Statement of Common Ground with Natural England (draft)

Revision 2

October 2025

Figure 7.1: Designated Sites and Ecological Mitigation and Enhancement Areas

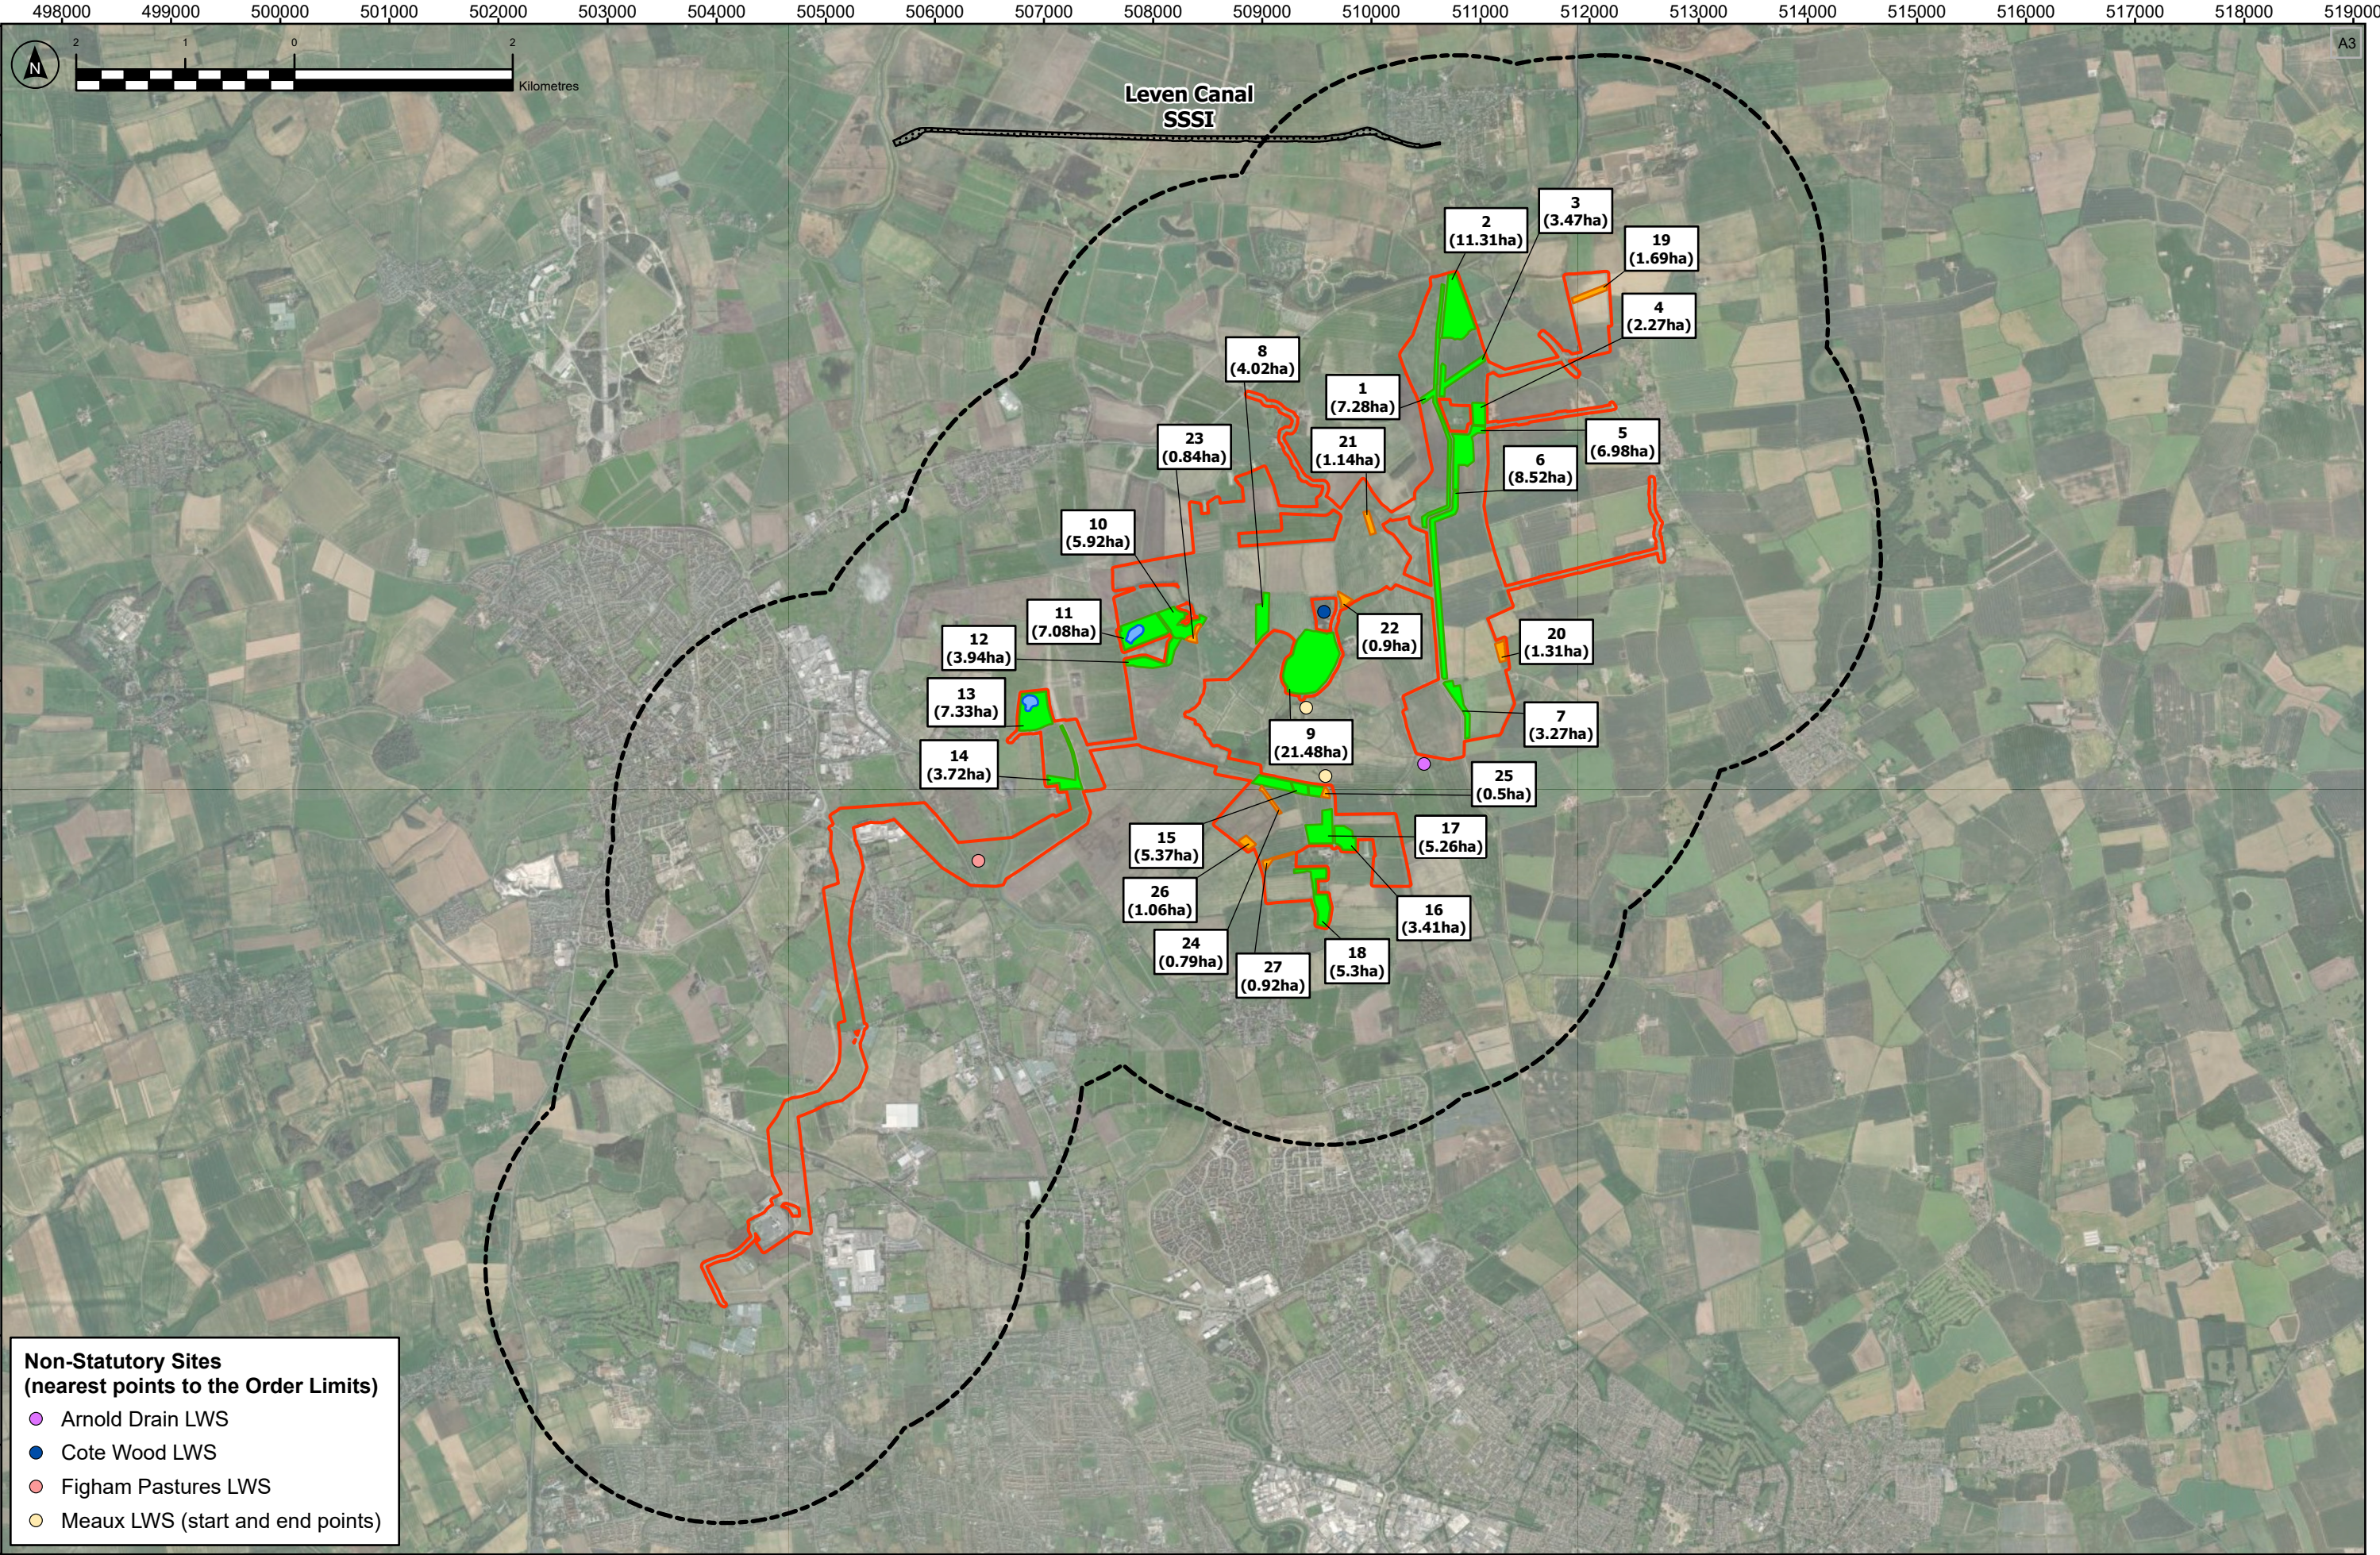
Ref	Topic	Natural England's Position	Applicant's Position	Status
		<p>this matter, specifically the proposed removal of the permissive path loops around mitigation area 9 (Fields D18) and 11 (Field E6). Natural England advised that stock proof fencing should be considered to separate permissive path users from all mitigation areas to prevent dogs from entering the mitigation areas.</p>	<p>dogs straying into the mitigation areas, along with appropriate signage (to provide footpath users with information on the ecological importance of the mitigation areas and the countryside code which includes ensuring all dogs are kept on a lead).</p> <p>Should the proposed changes be accepted by the Examining Authority, relevant documents would be updated as necessary and submitted at subsequent deadlines.</p>	
NE05	<p>Hydrology of the proposed mitigation areas</p> <p><i>Hydrology and Flood Risk</i></p>	<p>In their written representation [REP2-154] (NE1c) submitted at Deadline 2, Natural England welcomed the further information provided regarding the hydrology and soil types within the proposed scrape mitigation areas, and the predicted suitability of the locations for scrape creation. Natural England concurs that mitigation areas 11 and 13 are likely to be suitable for scrape creation and agrees that appropriate micro-siting of the scrapes can be determined by pre-construction hydrological studies.</p> <p>However, Natural England advises that further information should be provided regarding the 'suitable mitigation' measures</p>	<p>The Outline LEMP [REP1-056] that was submitted at Deadline 1 included further information regarding the viability of the proposed scrapes based on known information on the current hydrological statuses and permeability of soils in Mitigation Areas 11 (Field E6), 13 (Fields E13/E14) and 9 (Field D18). An initial review indicates that Mitigation Areas 11 and 13 are suitable locations to create scrapes successfully. Further assessment was provided in the updated Outline LEMP [REP1-056] that was submitted at Deadline 1 regarding the suitability and the potential carrying capacity of each mitigation area to deliver mitigation for the intended species and to set out that pre-construction</p>	Under discussion

NE07a	<p>In combination impacts</p> <p><i>Biodiversity</i></p>	<p>In their written representation [REP2-154] (NE1g), Natural England notes that Carr Farm Solar Farm, which is situated adjacent to mitigation area 11, has recently been consented. Natural England advises, therefore, that further assessment should be</p>	<p>The proposed mitigation areas for Carr Farm Solar Farm are directly adjacent to mitigation area 13 (Fields E13 and E14) and therefore compliment the Proposed Development's proposed mitigation.</p>	Under discussion

Revision 2

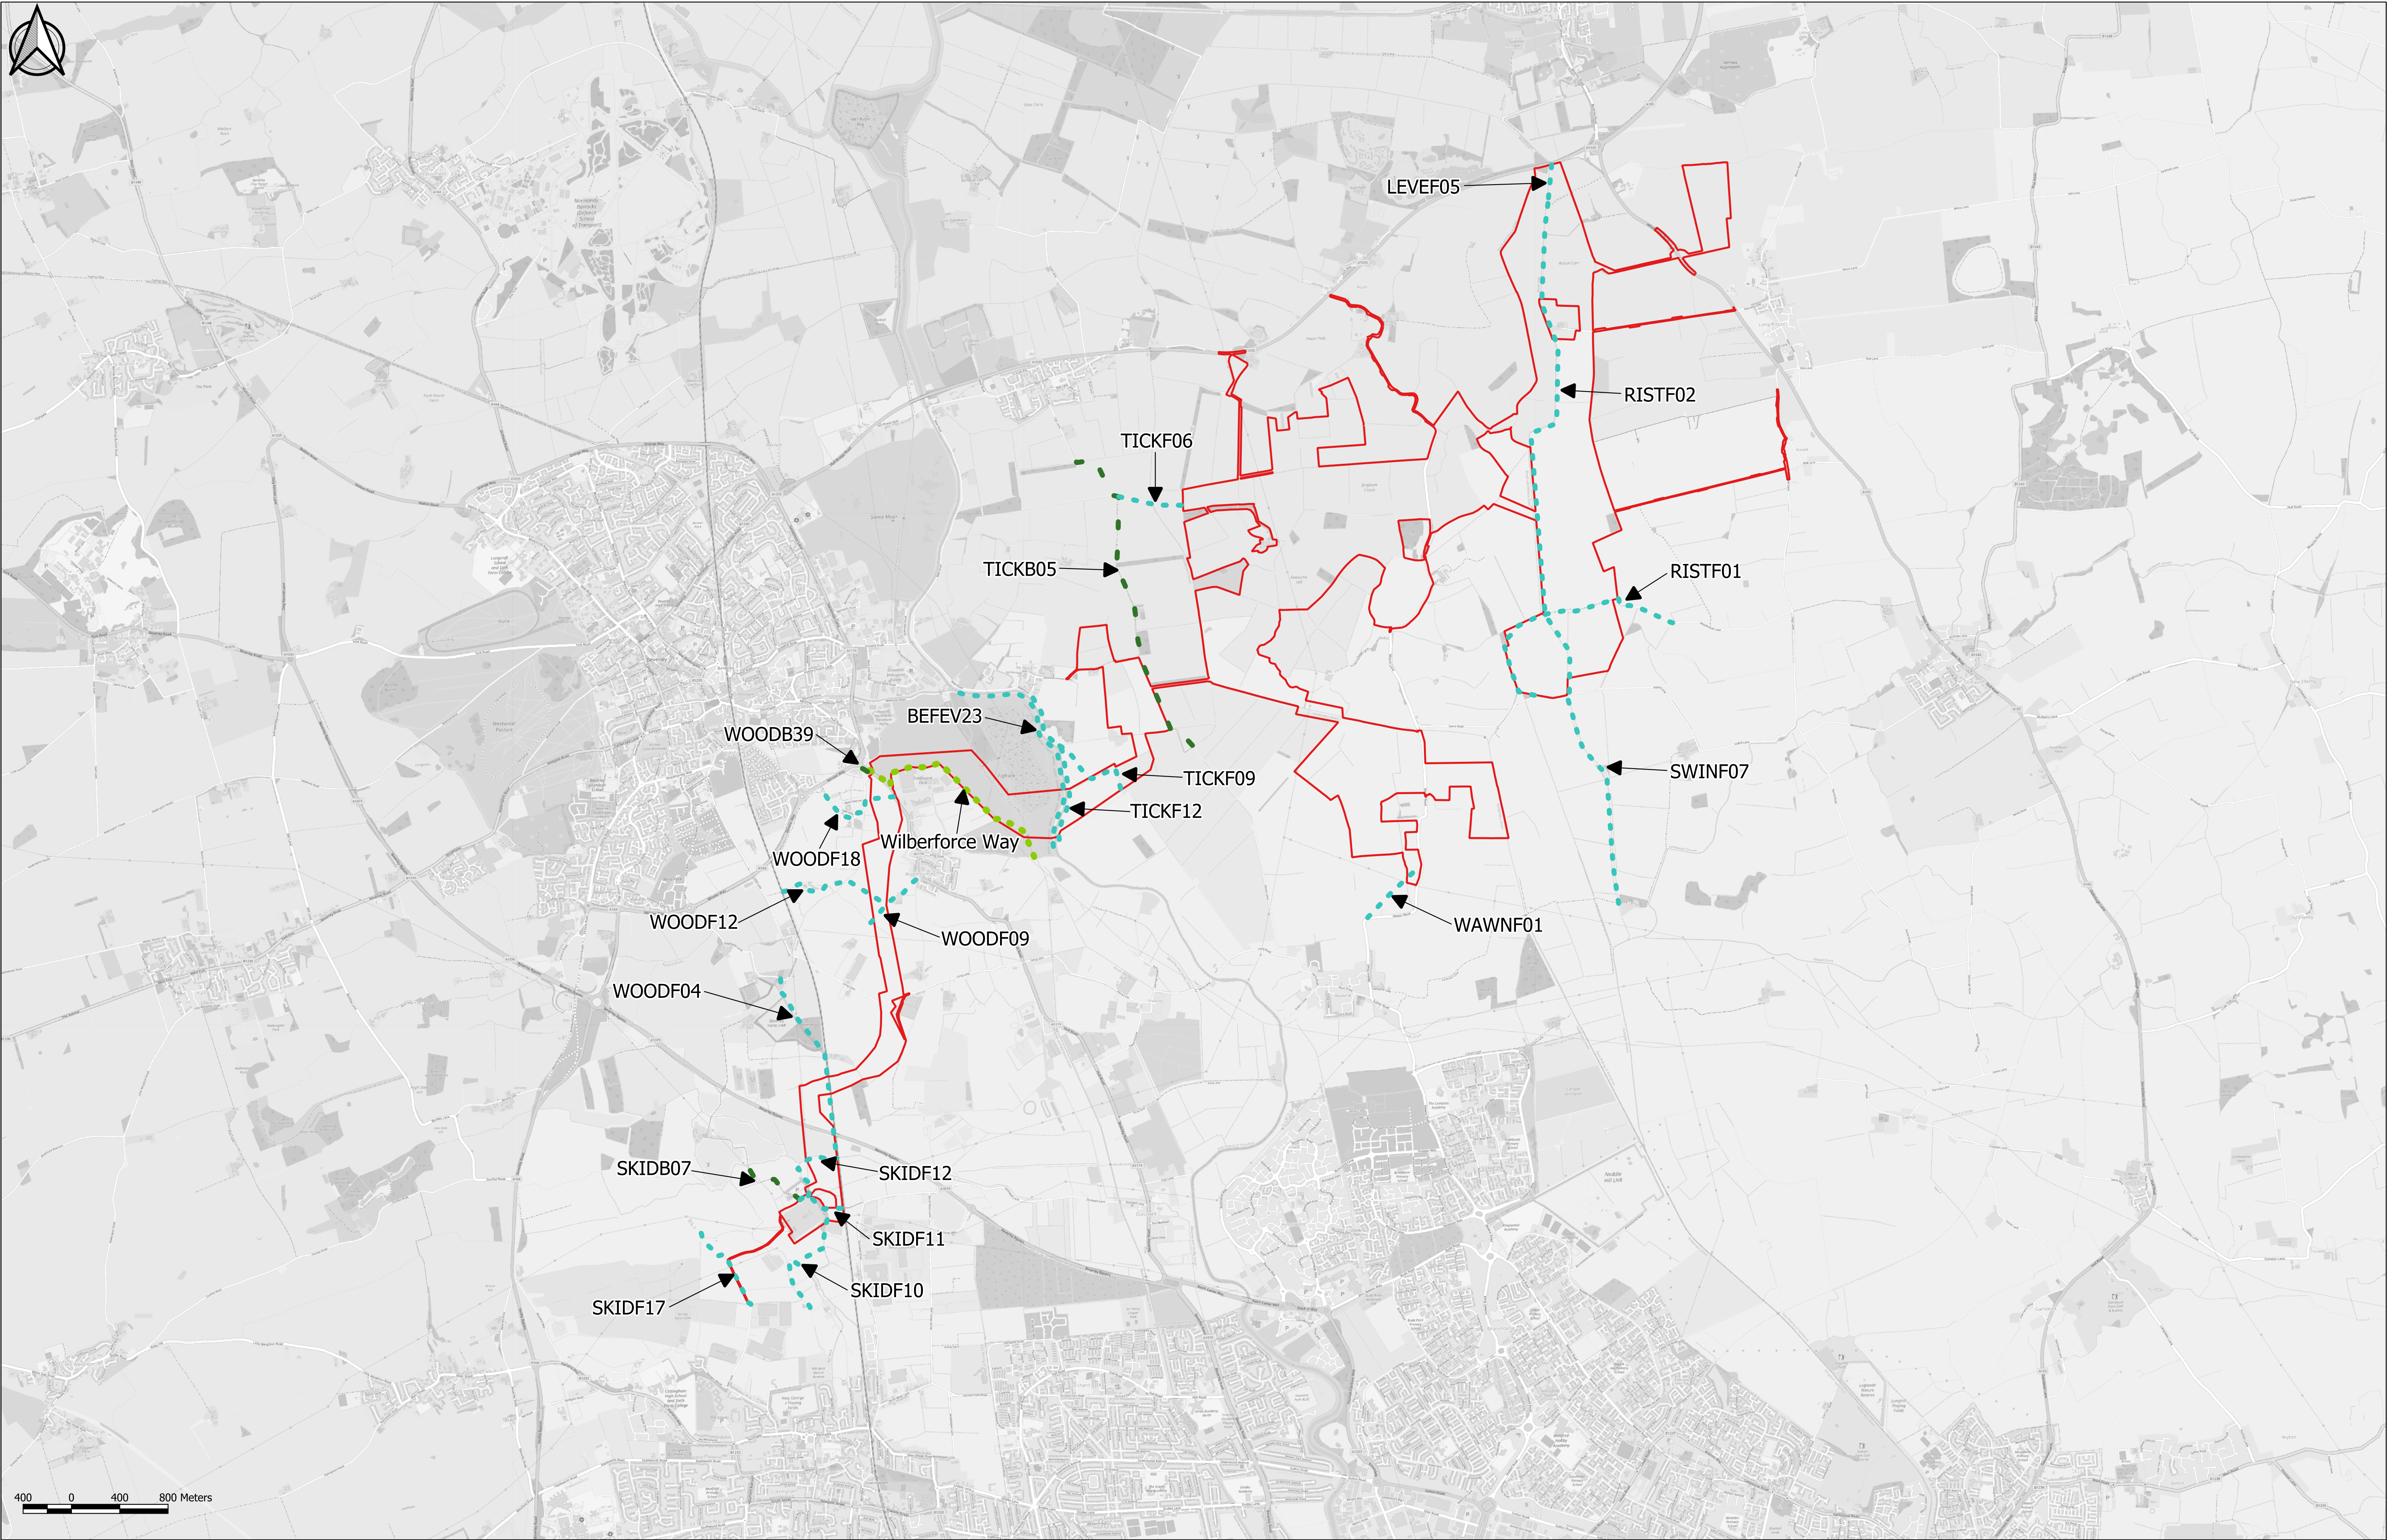
Ref	Topic	Natural England's Position	Applicant's Position	Status
		<p>representation [REP2-154] but also requested that an overall conclusion justifying the suitability of the site should be provided.</p> <p>In an online meeting on 11 September 2025, Natural England acknowledged that it was not possible to physically extend the capacity of mitigation areas at this stage, but the capacity can be increased through effective management and monitoring of the mitigation areas.</p> <p>Natural England will review the updated information and provide comments at Deadline 4.</p>	<p>the updated Outline LEMP [EN010157/APP/7.5 Revision 6], which is submitted at Deadline 3, has been amended to address each respective issue.</p>	
NE04	<p>Permissive paths and the proposed mitigation areas</p> <p><i>Biodiversity</i></p>	<p>In their relevant representation [RR-012] (NE1b), Natural England noted that Figure 3.4 Indicative Environmental Masterplan [APP-058] detailed proposed permissive walking routes around mitigation areas 9 and 11 and advised that the impact of these paths on the functionality of the proposed mitigation areas should be assessed in the HRA. Natural England confirmed via email on 10 September 2025 that overall, it welcomes the Applicant's proposed changes to address</p>	<p>As set out in the Third notification of proposed changes to the DCO Application [AS-017], the Applicant is proposing amendments to the permissive path routes around mitigation areas, including mitigation areas 9 (Field E6) and 11 (Field D18), to address this matter, following consultation with Natural England. The Applicant is also proposing to install 1m-high post and rail fencing with wire mesh between relevant sections of permissive path and mitigation areas to prevent path users and</p>	Under discussion
